**From:** Contact Centre (CRM) <contact@ribblevalley.gov.uk>  
**Sent:** 22 May 2023 11:40  
**To:** Planning  
**Subject:** Planning Application Comments - 3/2023/0325 FS-Case-518012559

**Planning Application Reference No.:** 3/2023/0325

**Address of Development:** land adjacent to no.9 Old Road

Drawing Key:

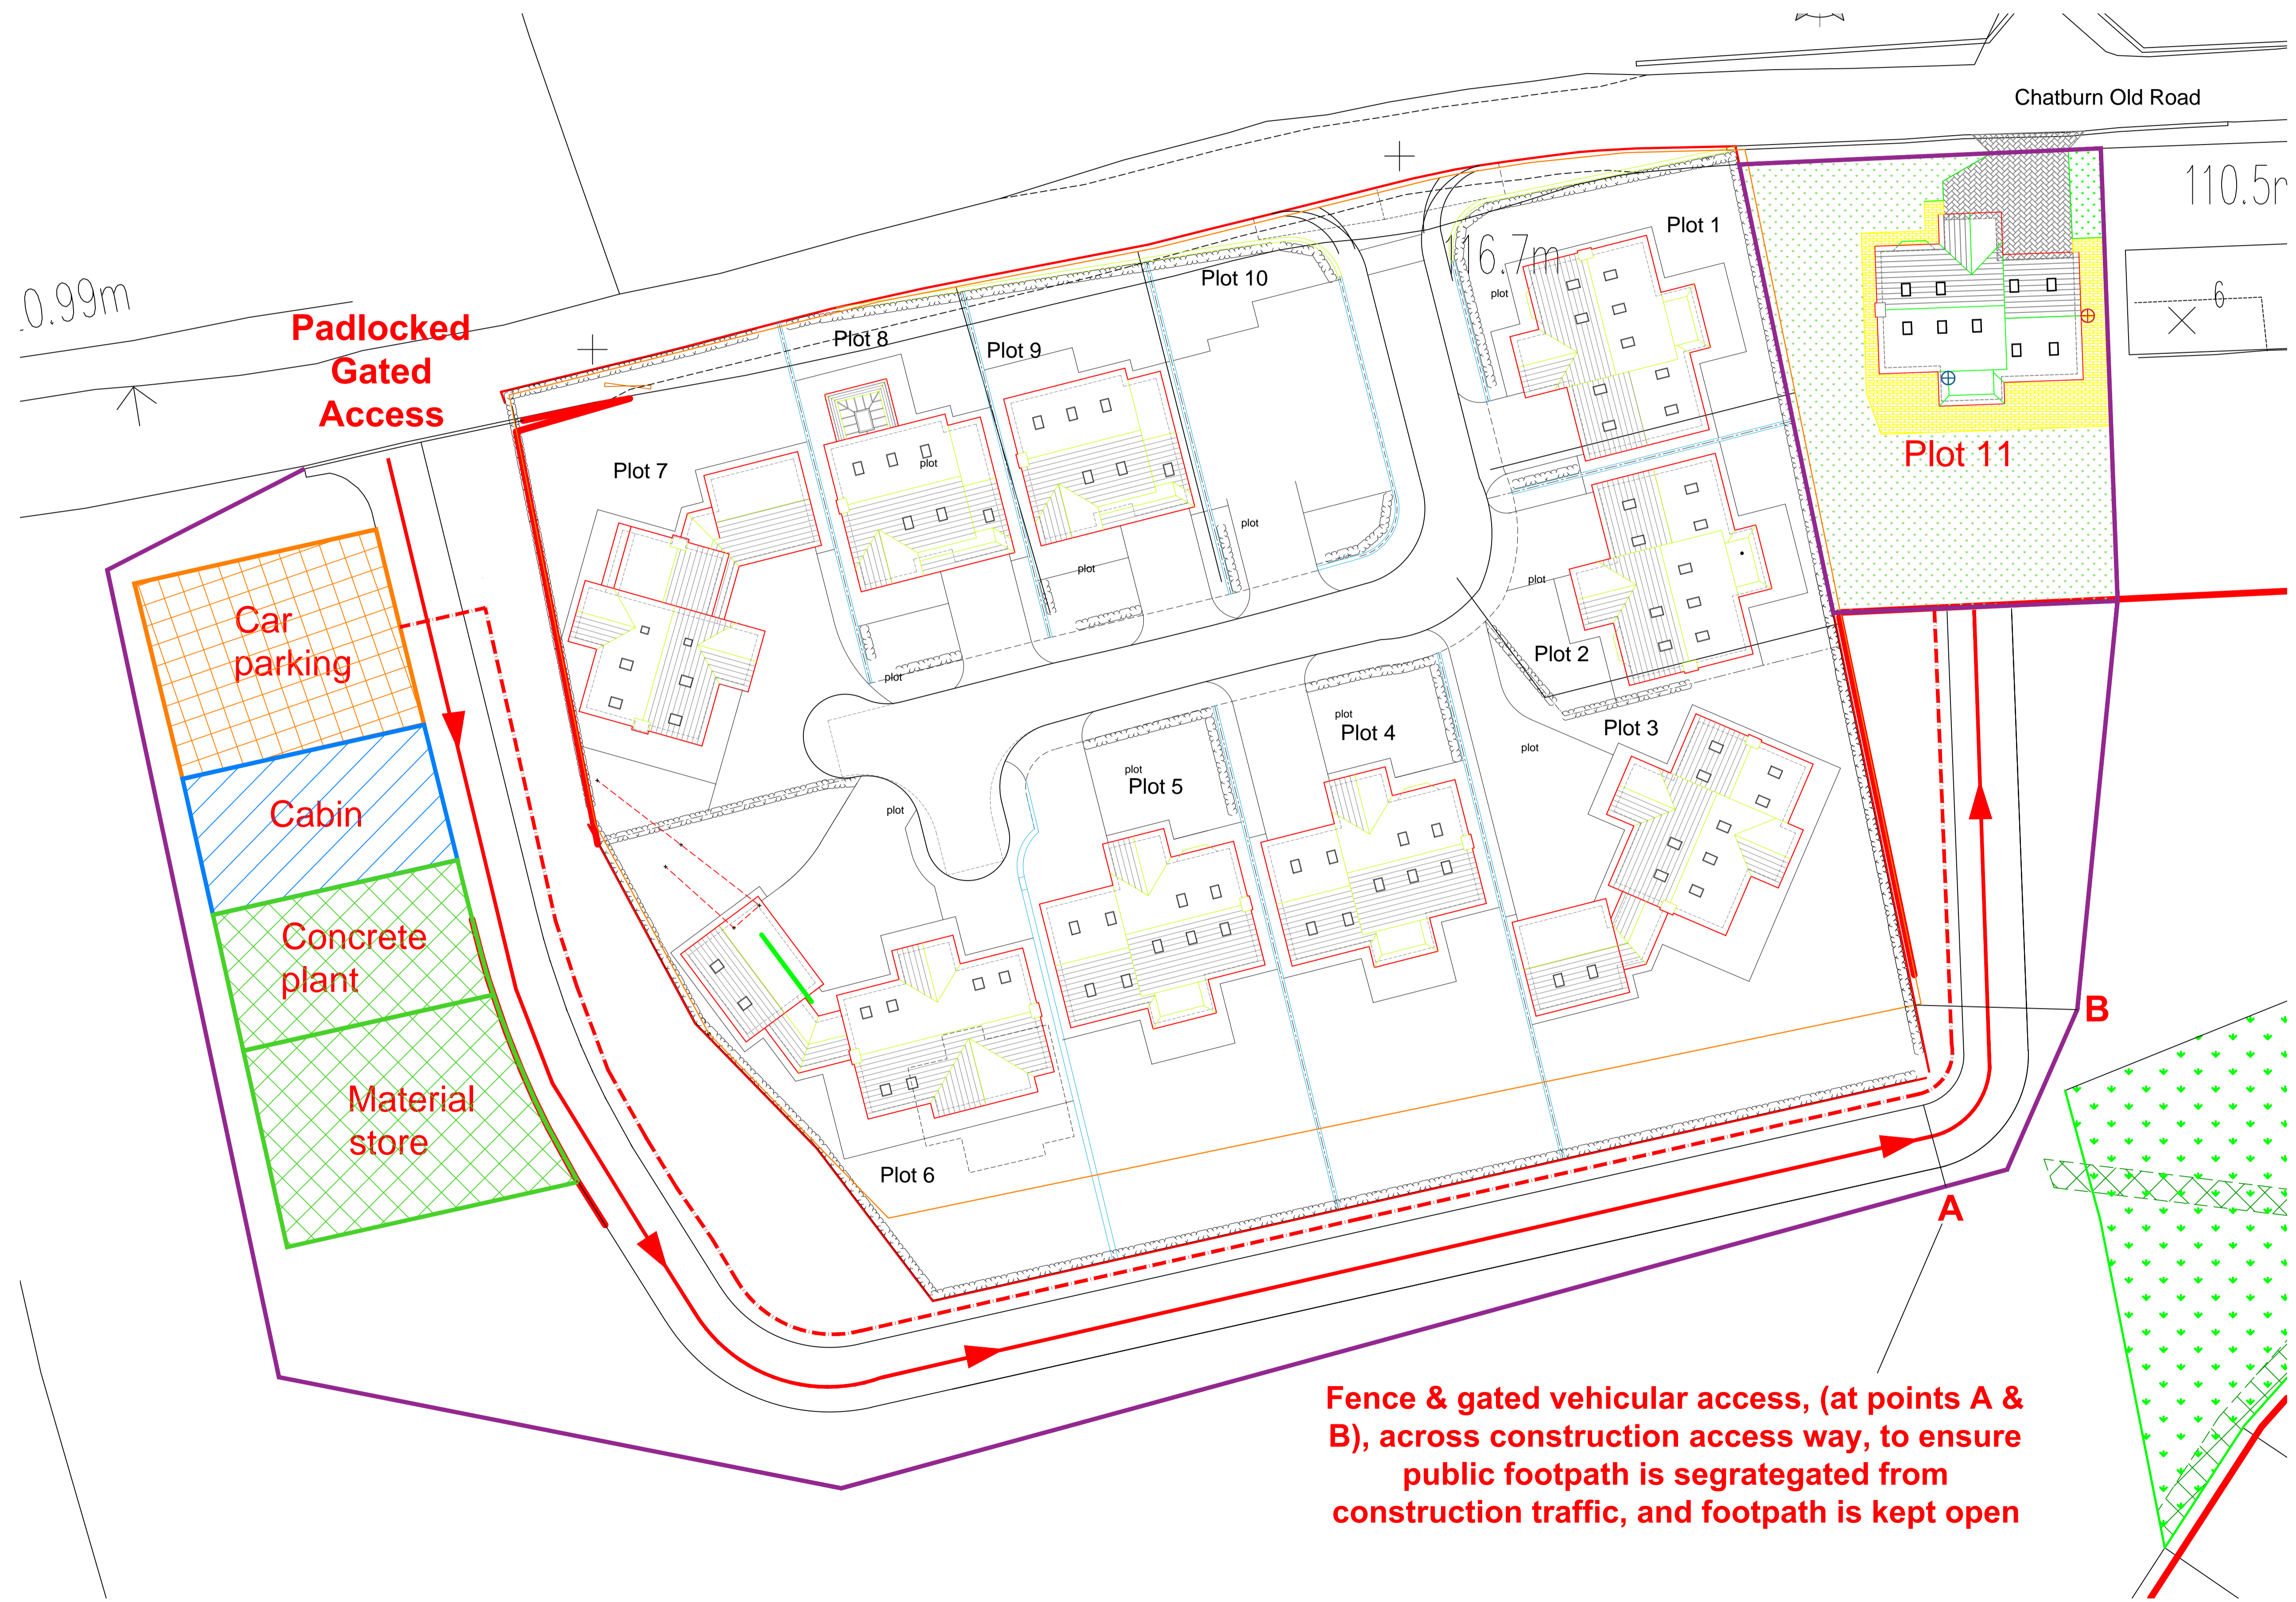
**Public Footpath Hazard:-** The plan apparently only indicates a footpath for site workers, whereas that is the route of the current public footpath but it stops at the fence of plot 11 . However, the footpath needs to continue down to Crow Trees Brow. Also the plan shows no protection to the footpath from the site traffic route but the statement claims only low barriers protect the footpath from the site traffic. Dog walkers regularly use that route and the site traffic will be a problem so close to the footpath. The plan and statement claim a padlocked closed site so how can the public access the footpath when the site is closed? There needs to be a plan showing exact clarification of public footpath route, access and protection.

**Access to plot 11:-** We are not aware of any planning permission for the access road that is currently in place as shown on the plan. Also the proposals state that an entrance to Old Road will be constructed as a first stage. If all further access is then from Old Road this will present a significant problem to all Hare Hill Croft residents and all users of Old Road who need to turn at the first turning point opposite the site.

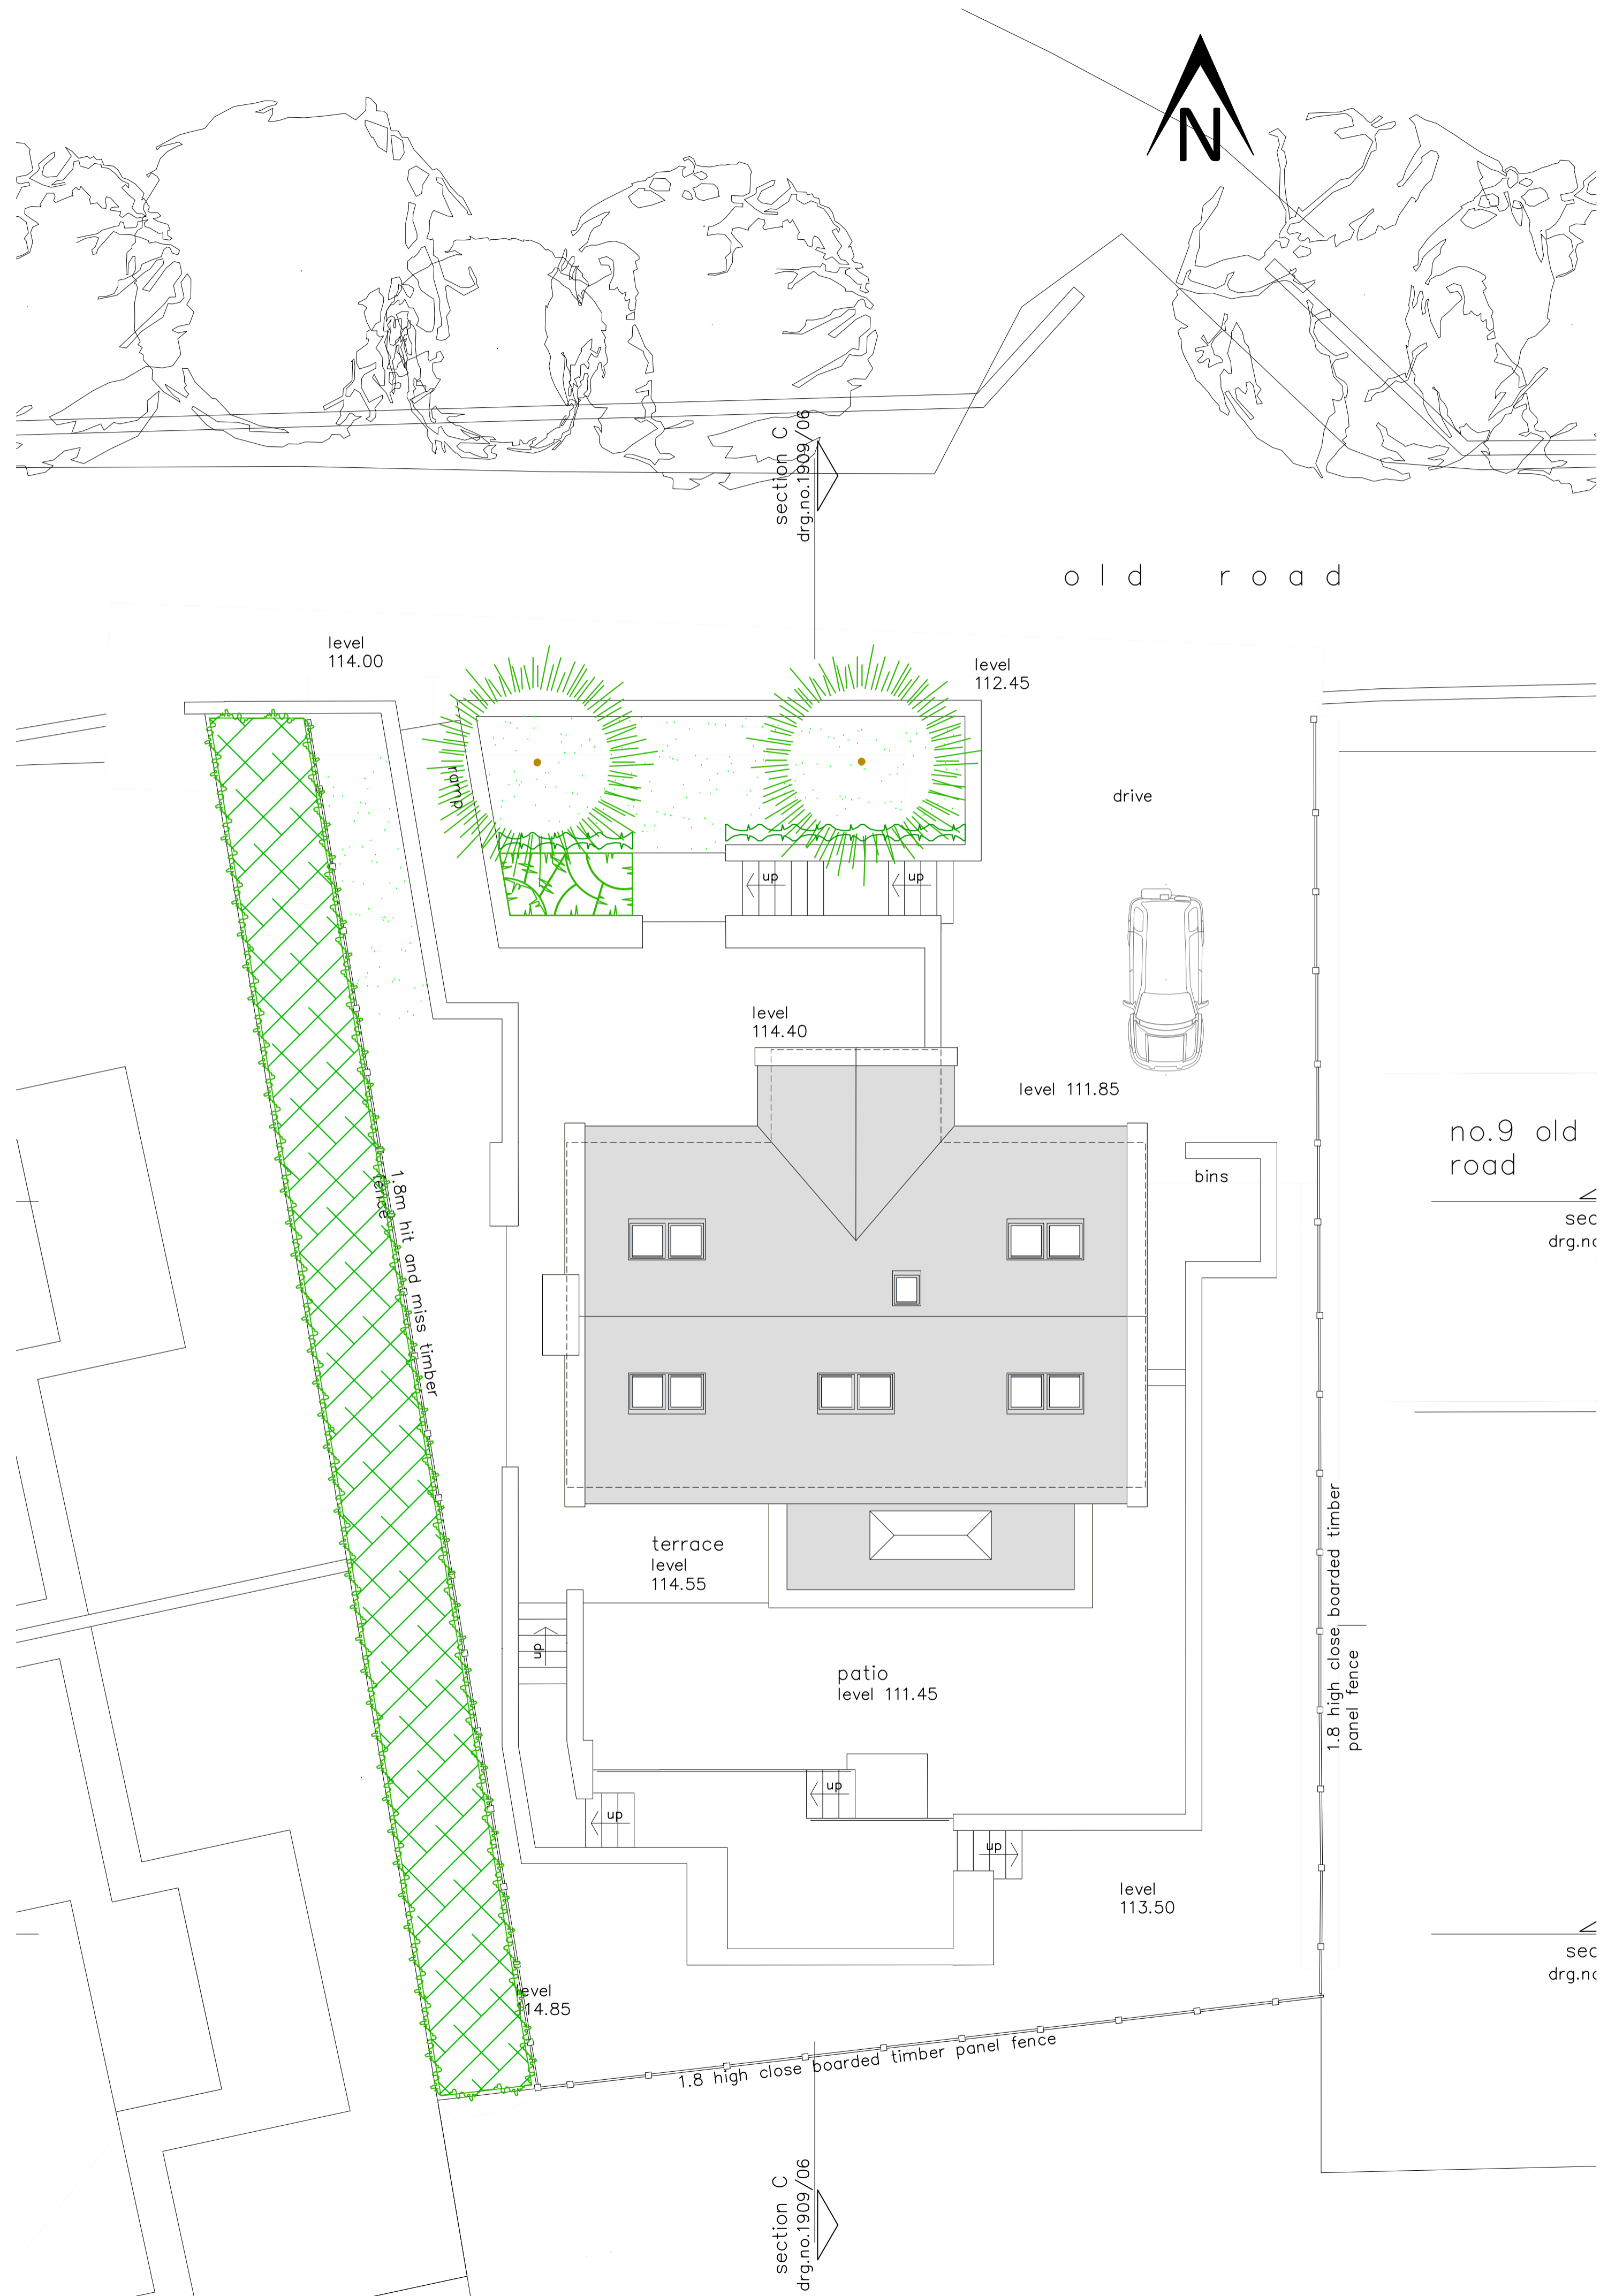
*Malus sylvestris* (Crab apple) has been specified as one of the trees at the front of the house. I believe this is not an appropriate choice near steps as the crab apples fall and create a sticky mess on the surface. The leaves of *Betula Pendula* support 300 species of insects so might also be problematic so close to the house front. It is also north facing with dense woodland directly opposite. I would suggest an alternative of liquidambar syraciflue 'Lane Roberts', *Sambucus Nigra* or replacing both trees with 2 no. *Pyrus Chanticleer*.
